Jeanie Bourke - RE: Canal Landing Fire Risk Management Life Safety code analysis.

From: Jeanie Bourke [mailto:JMB@portlandmaine.gov]
Sent: Tuesday, September 09, 2014 2:42 PM
To: Stephen Bushey
Cc: Laurie Leader
Subject: Re: Canal Landing Fire Risk Management Life Safety code analysis.

1 SECOND FLOOR / MEZZANINE FLOOR PLAN  
SCALE: 1/8"=1'-0"

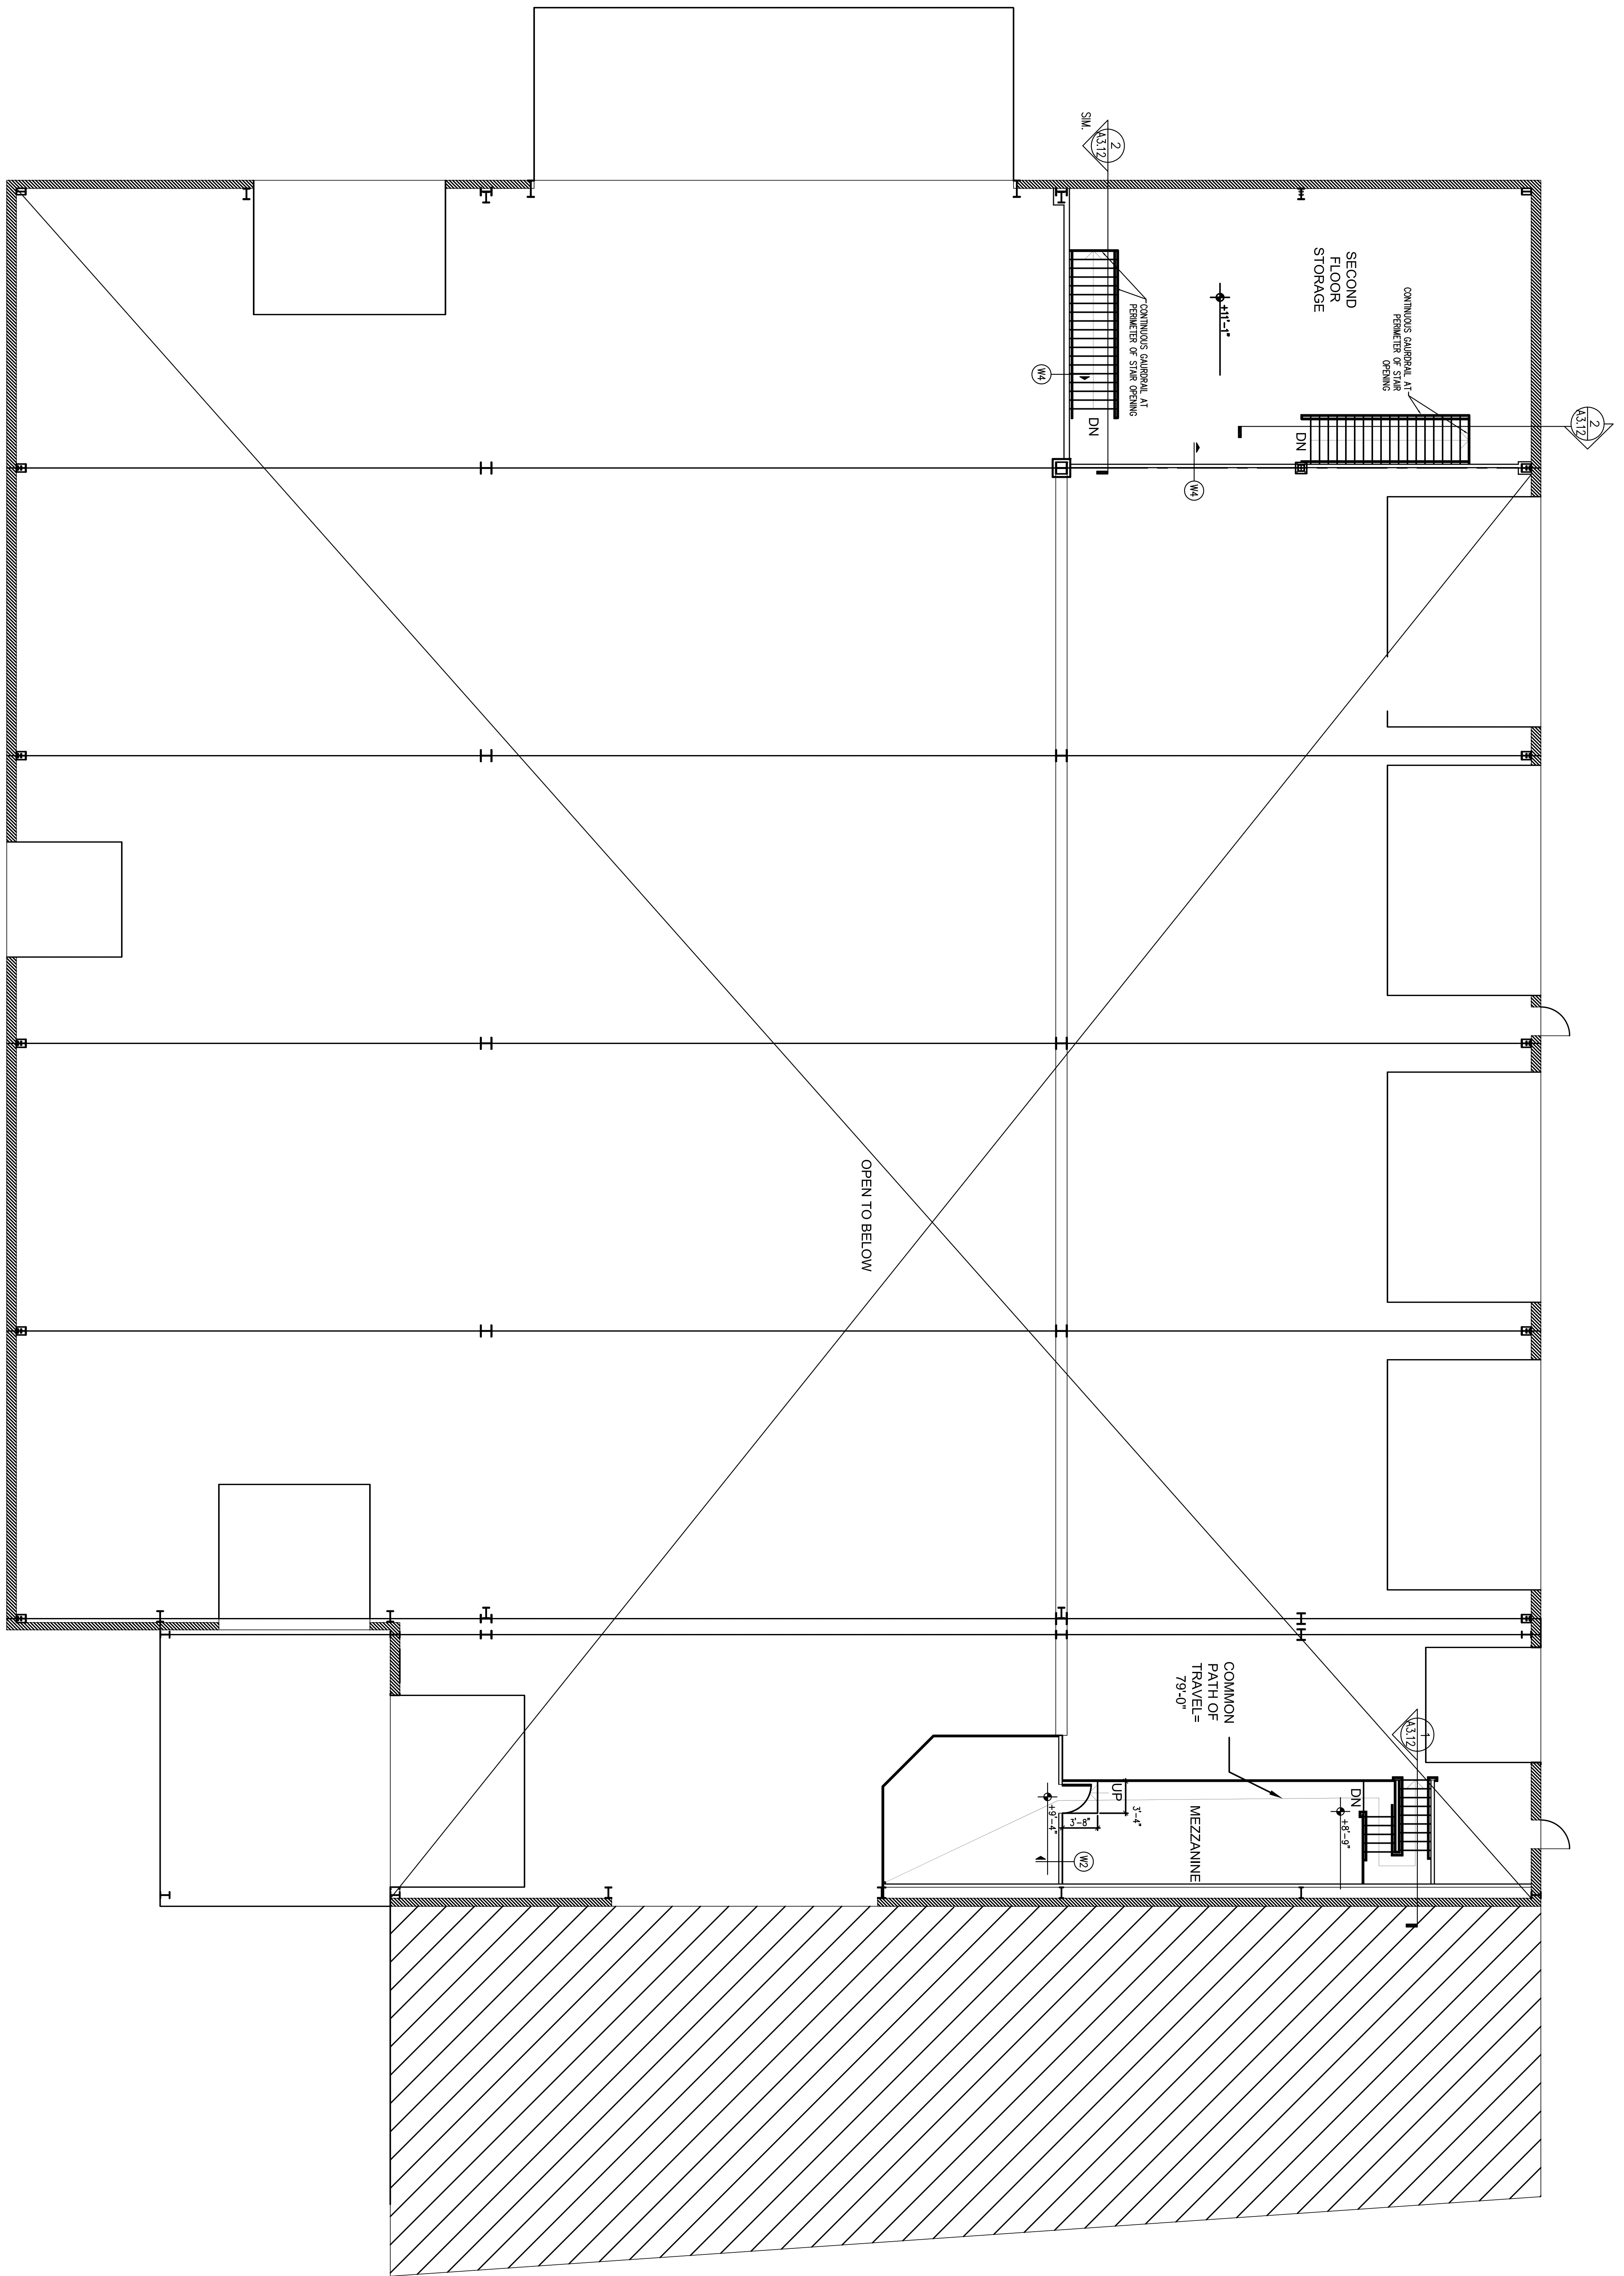
8. Please confirm the scope of this project concerning the 2nd floor/mezzanine. The Essex plans show this as part of this building construction, however, there are no other floor or egress plans submitted, as is consistent with the FRM report. Also, the Irishspan plans show future columns on Sheet 3.0. Will this be on a Phase 2 permit? **There will be only a 30 x 50 mezzanine for storage constructed now. The building is designed to support additional mezzanine area in the future.**

4. The Cert of design app is incorrect on the website about the sprinkler being compliant with "IRC". At one time it had been changed to IBC, admin is working on it. Just use this form for now.
6. Yes, typically the set is fully stamped.
7. Please have this noted on the plan for future stairs to be built or remove from the plans.
8. I assume the details of the mezzanine and stair access will be included on the plans, architectural and structural.

Date: 25 September 2014
Scale: 1/8" = 1'-0"
BUILDING ELEVATIONS

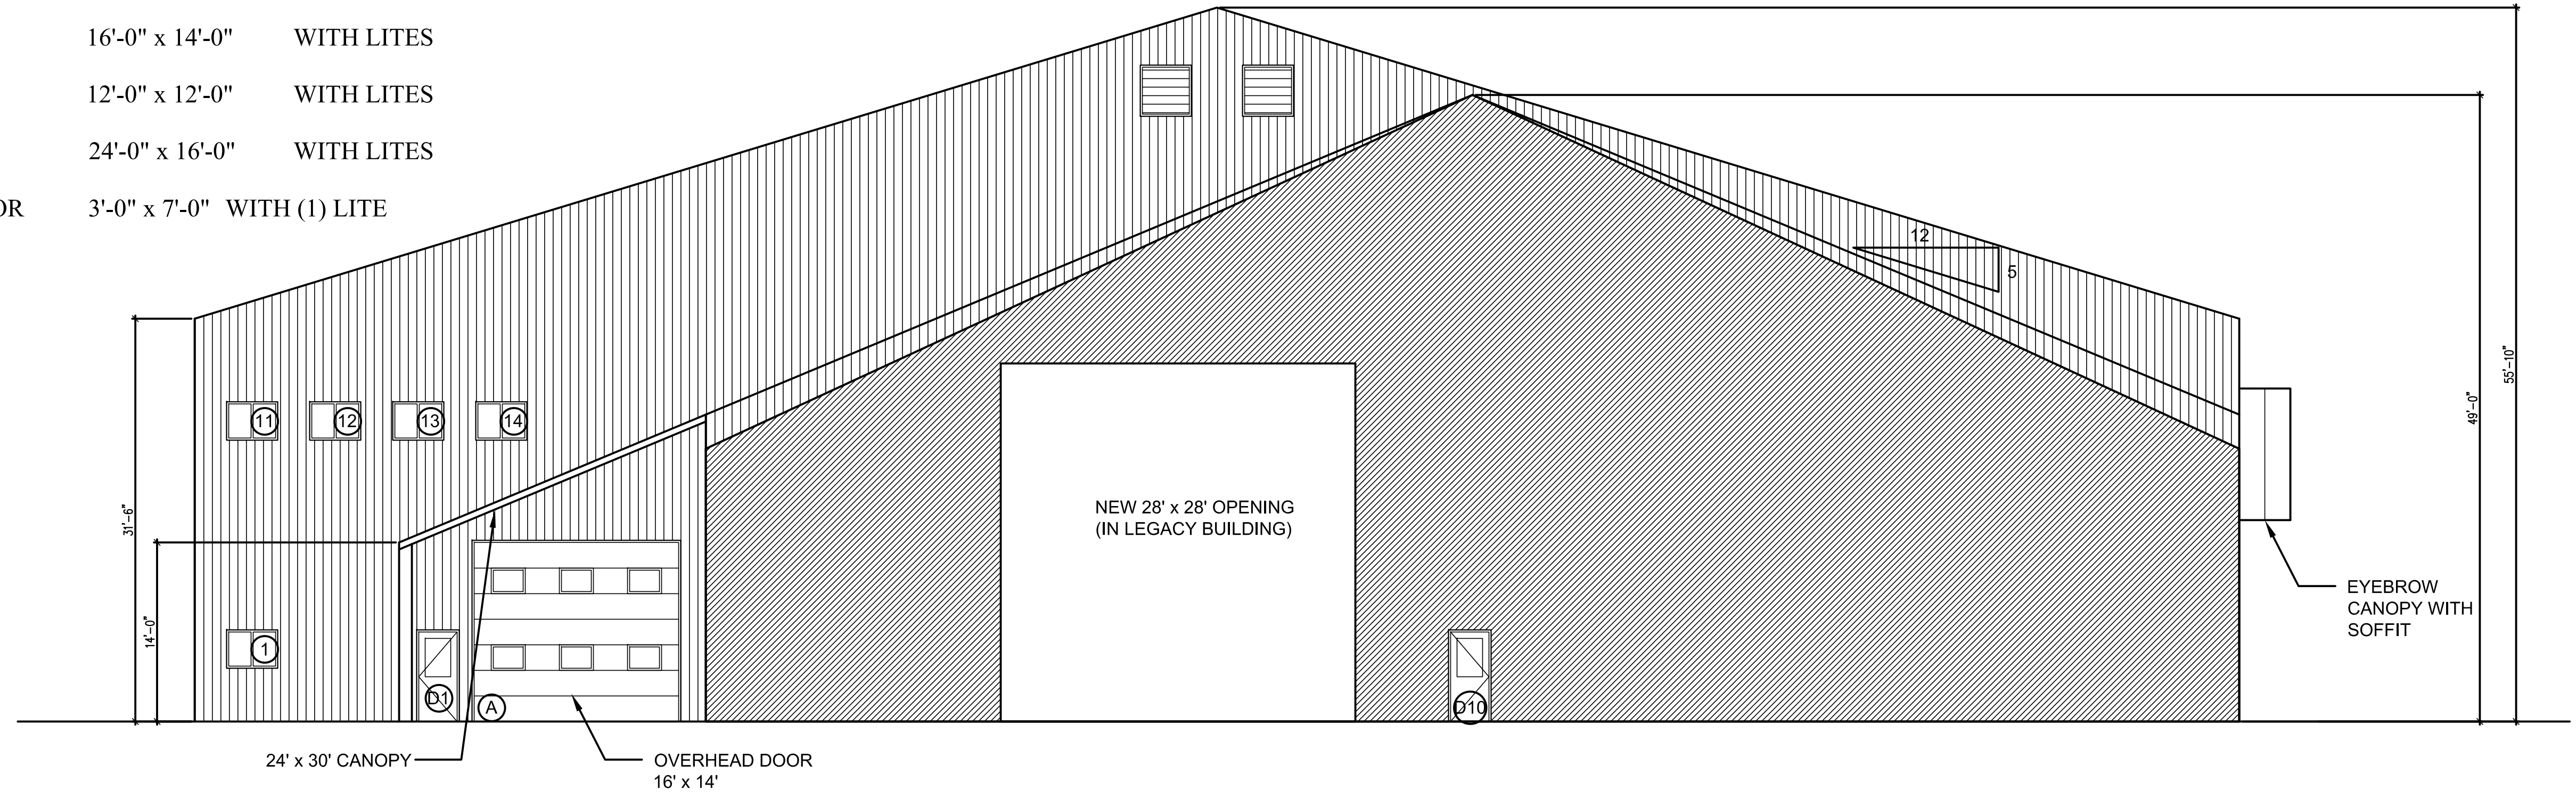
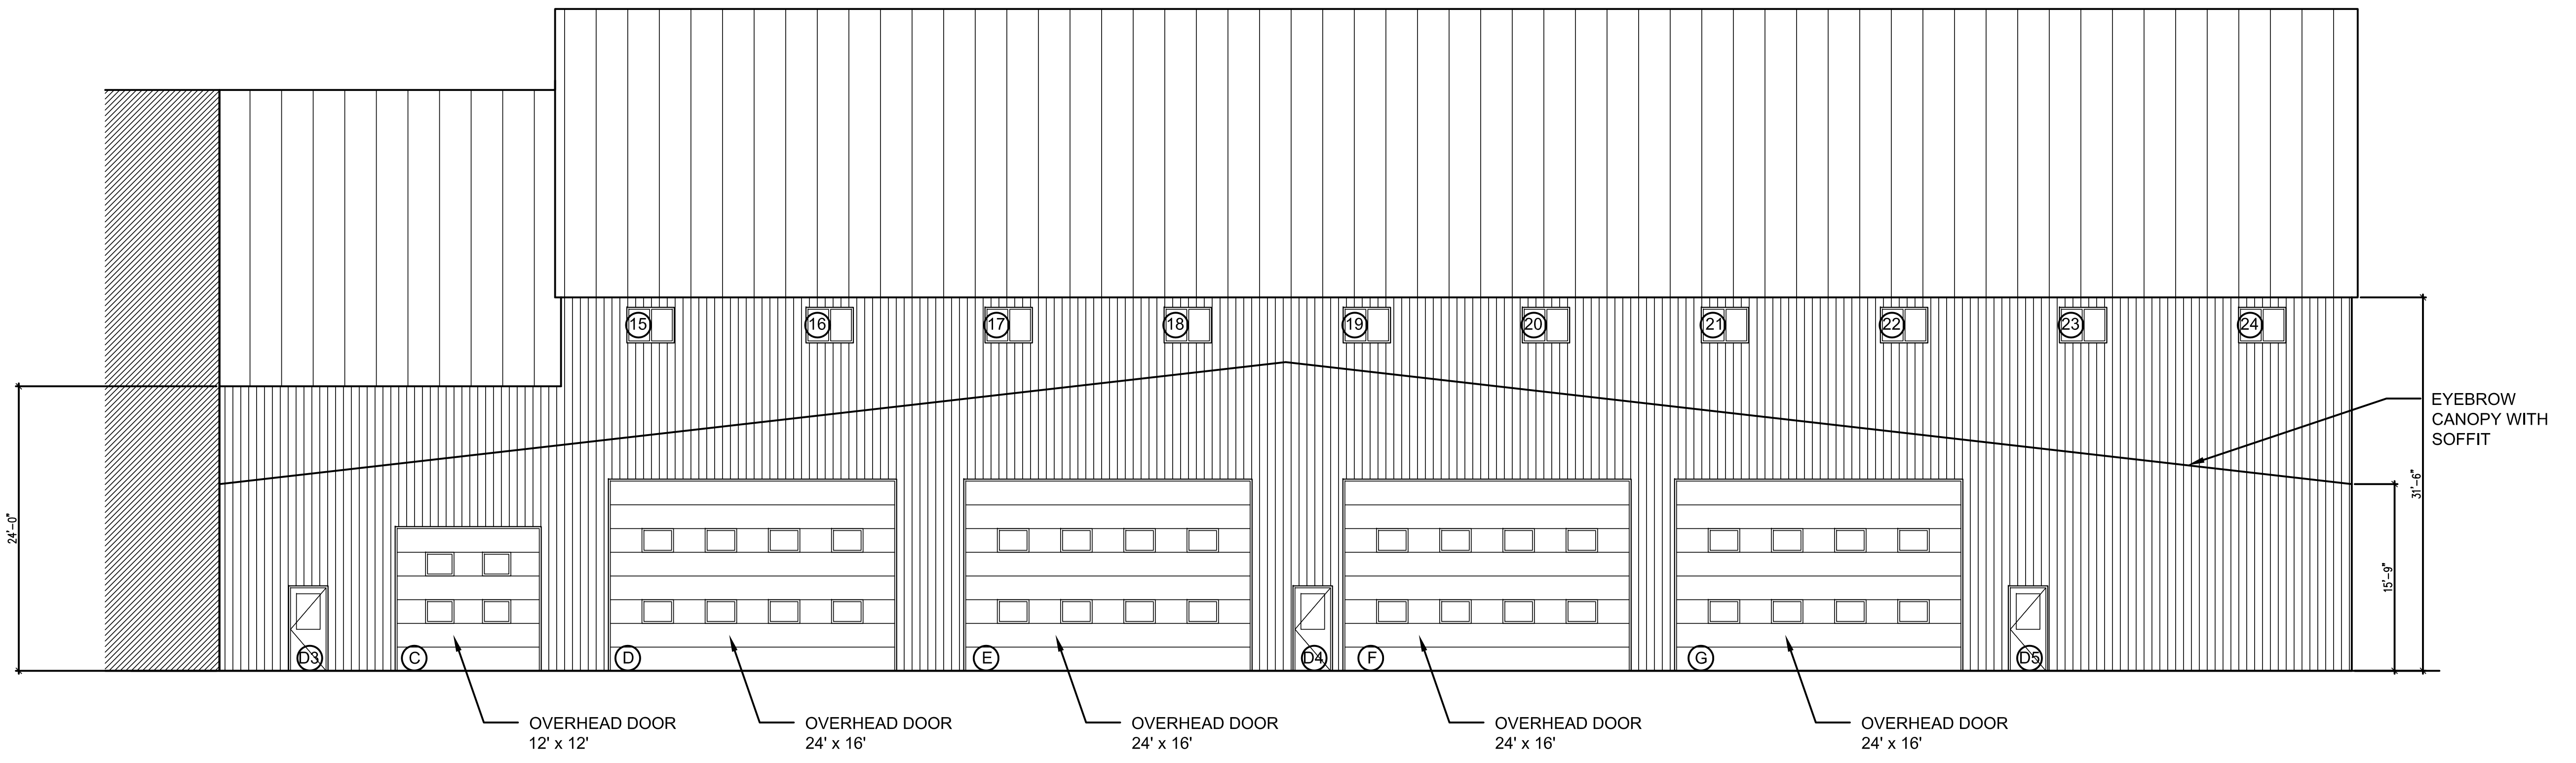
7. Sheet 2 of the Irishspan drawings shows a balcony and exterior stair from the 2nd floor, however there are no construction plans, nor is this shown on the site plan. **These stairs are for future installation only at this time.**
